To: Joey Davis
Subject: Wood Grove

Hi Joey, I have reviewed the plans for the pool at Wood Grove. If you can clarify just a few things we should be able to get an approval.

2 Enlarged Restroom Plan
1/2" = 1'-0"

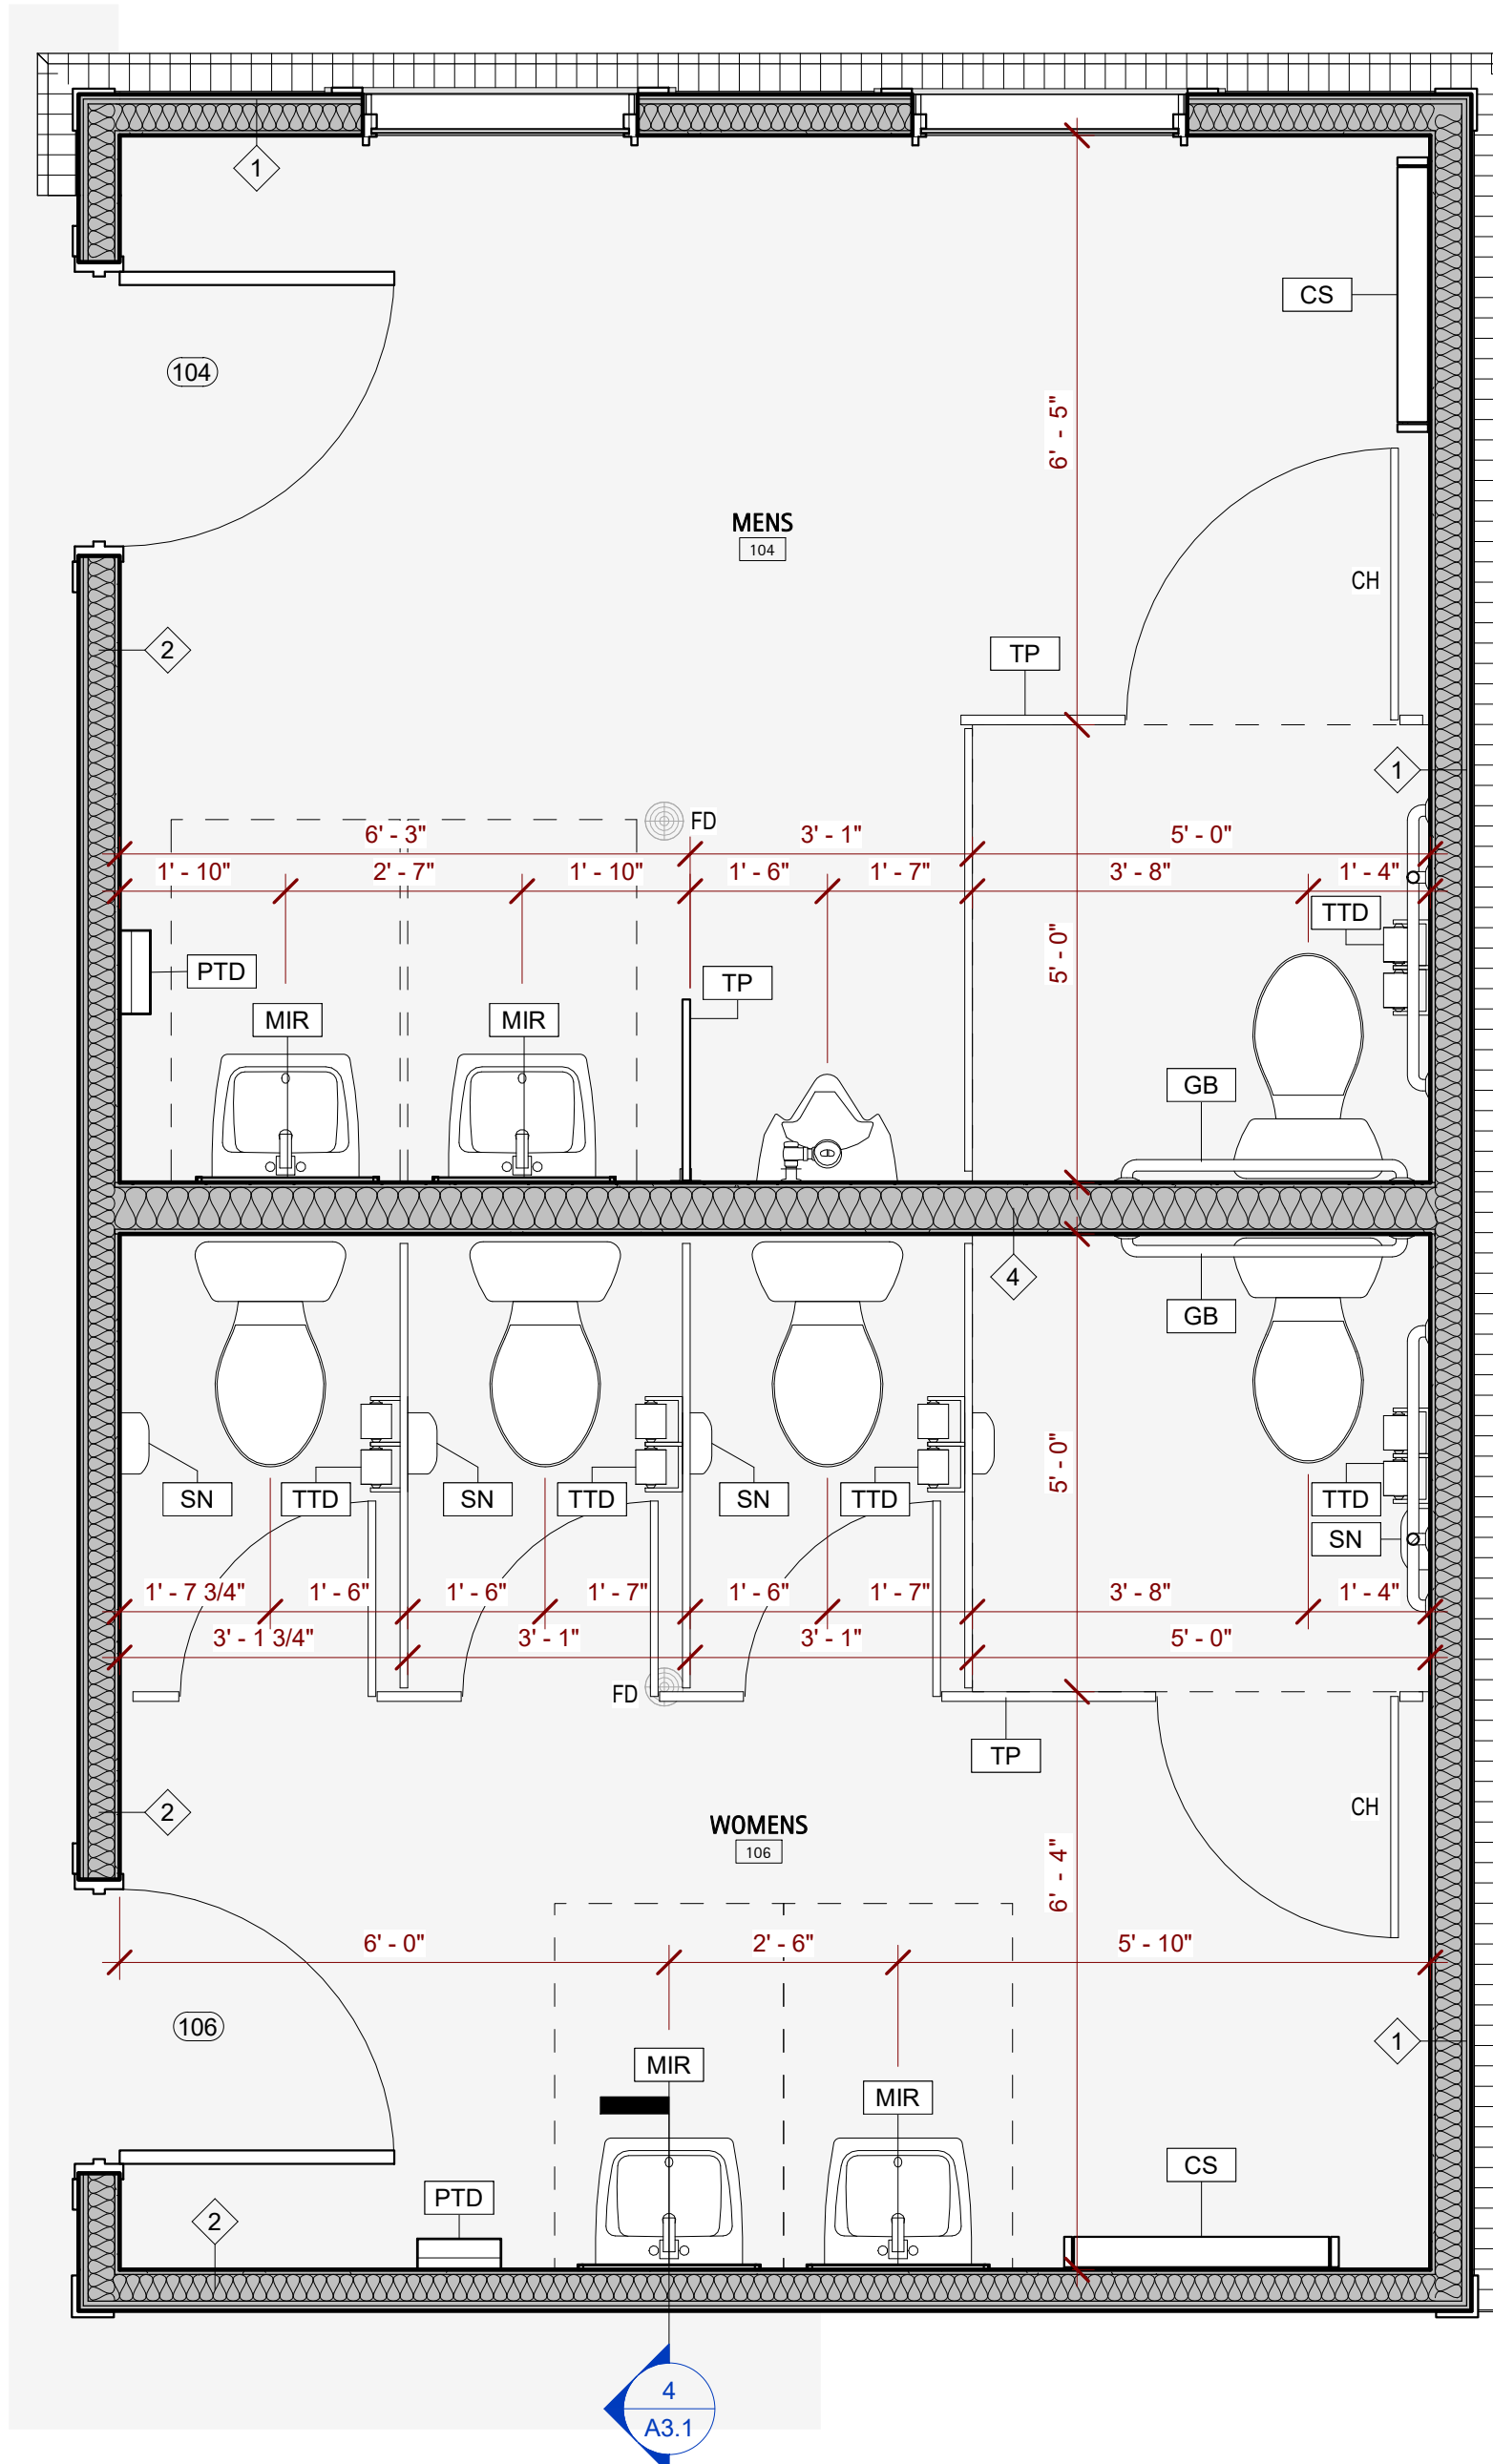
- Will there be deck drains?
- The overall length of the pool on the plans is 45'2" but the data block shows overall length of 42'2". Can you state which is correct?
- No soap dispensers are shown in the lavatory areas on the enlarged restroom plan
- The autofill line is reflected on P2 water supply but is not included on SP4 enlarged pump room plans
